From: Nicola Swann [REDACTED]
Sent: 16 June 2021 12:06
To: Planning.Responses <Planning.Responses@arun.gov.uk>
Subject: Pagham responses

P/81/21/HH – 28 Greenways Pagham PO21 4QE. Removal of existing conservatory and erection of single storey rear extension, single storey front/side extension and detached outbuilding.

PROPOSED DETACHED OUTBUILDING AT 28, GREENWAYS, PAGHAM
FOR MR. & MRS. T. HARRIS.

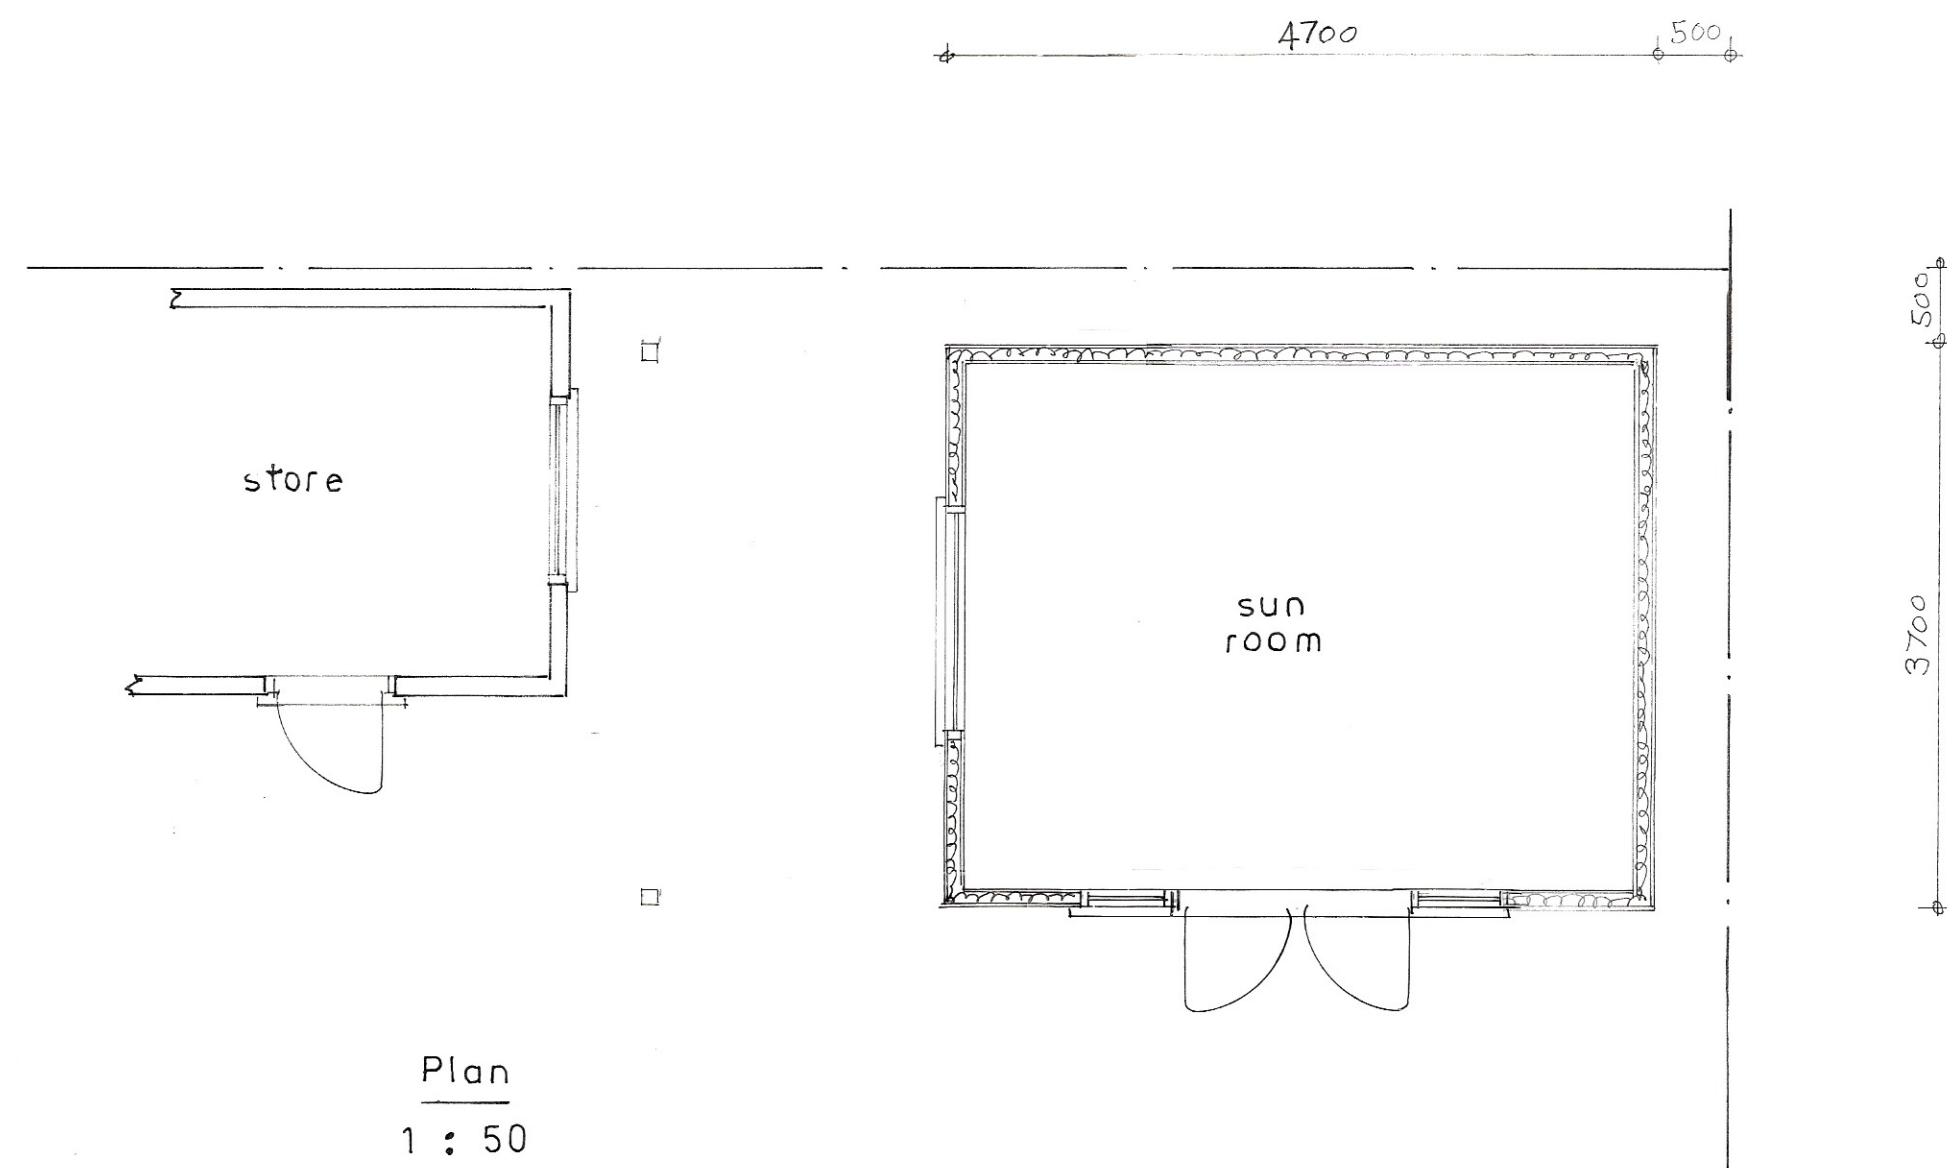
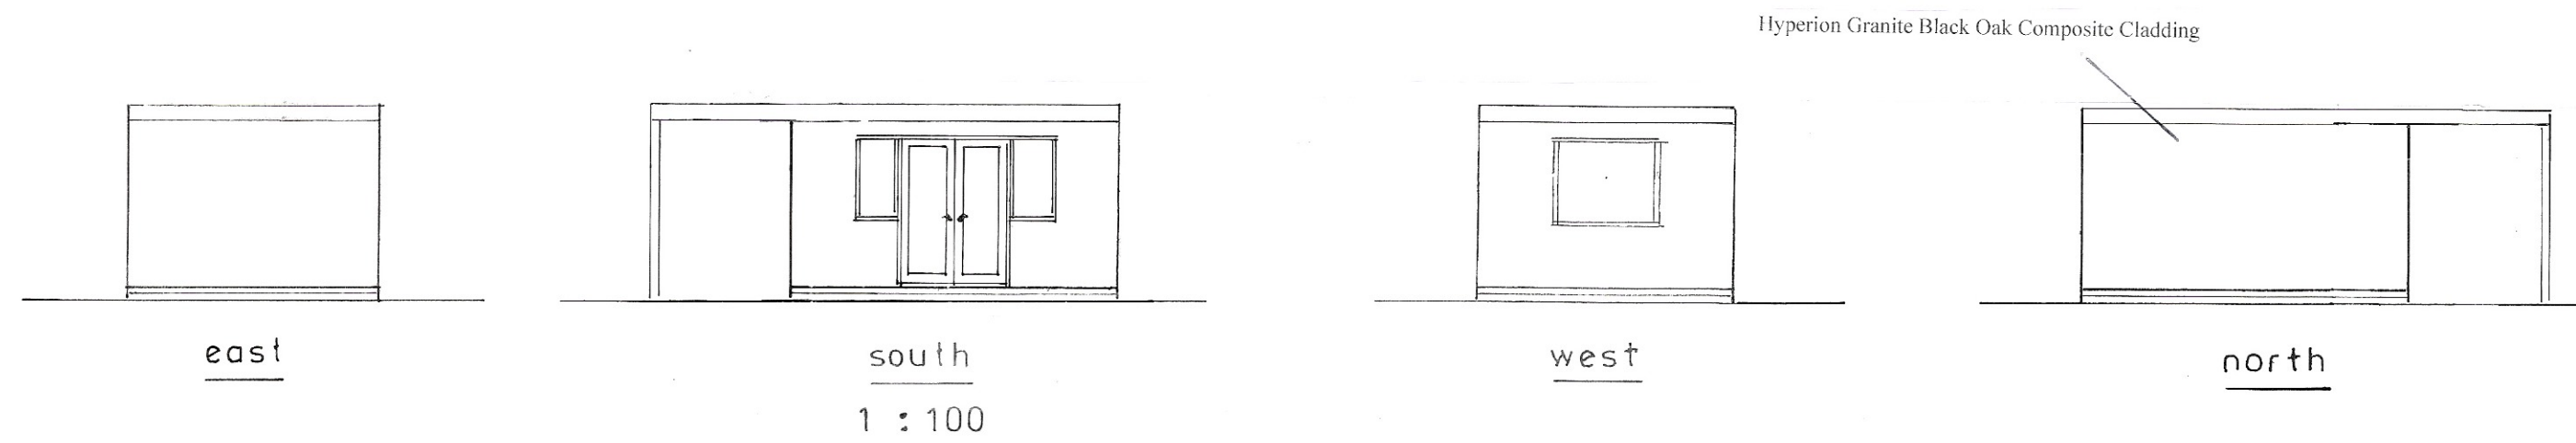
NO OBJECTION. The Group noted the height of the outbuilding was not provided, and was assumed to be of a size that would not be obtrusive to neighbouring properties.
